AW-159-11-TC – 24 Kingsway – Tree surgery.

OBJECTION – AW/159/11/TC – Tree surgery, 24 Kingsway,
Craigweil House Conservation Area

THE WHITEHOUSE, CHANNINGSWICK, CHALGHEWELTON - SEA
NOT TO SCALE

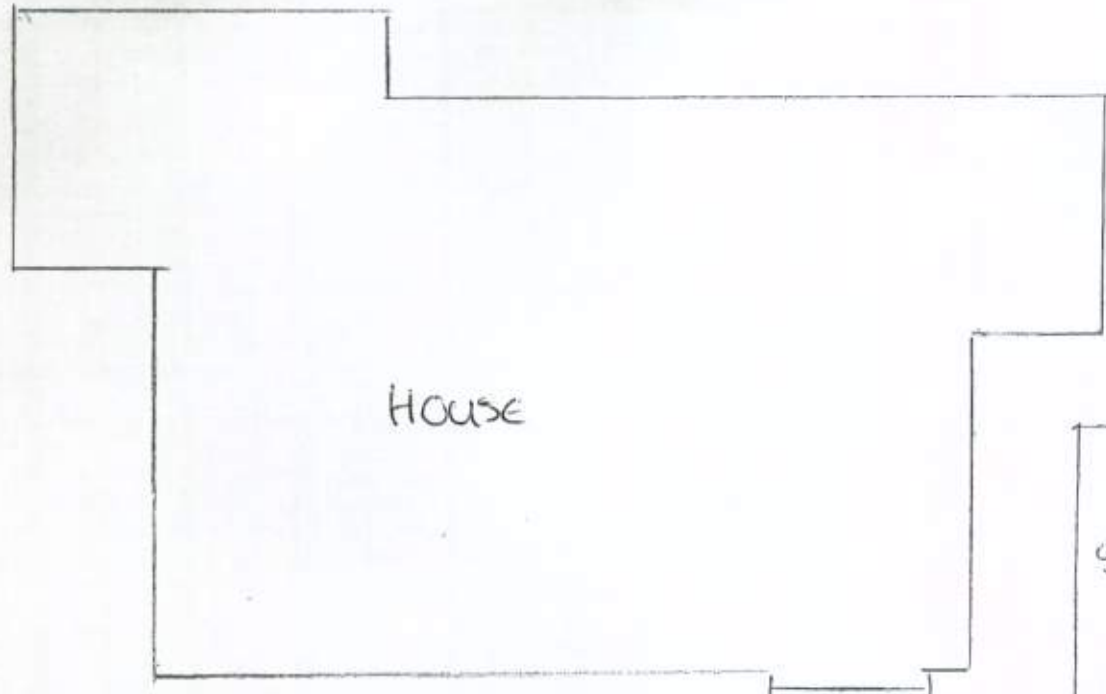
The Holly, if its identification is correct (and identification is not easy due to the crude drawing and absence of a photograph) is the tree which, within the last 2-3 years was massively lopped from top to bottom on the south/west side without consent. This distorted the tree and left it looking like the Portsmouth Spinnaker Tower and not a tree.

Reduction of any tree by 50% is considered by us and by Mr. Tony Kirkham, Head of Arboriculture at Kew Gardens, to be excessive – particularly in the current ongoing drought conditions, now in the fourth consecutive year. This view is supported by BS 3998 : 1989 which at paragraph 13.4.2 says '*Very substantial crown reduction should, ideally, not be made during a single growing season since severe loss of leaf area and multiple wounding may impair a tree's defences against diseases and decay*'.

At paragraph 13.6.2 it states '*The percentage of crown to be removed should be stated, but the leaf area removed should not normally exceed 30% of the original coverage*'.

The proposed extensive reduction in height would undoubtedly cause severe harm to these trees which, in our view, have been severely neglected for a great many years (as with the Macrocarpa to the south of the house) but cannot justify desperate measures of damaging topping in one operation.

Subject to Mr. Brewster's views, we ask that this application be REFUSED.
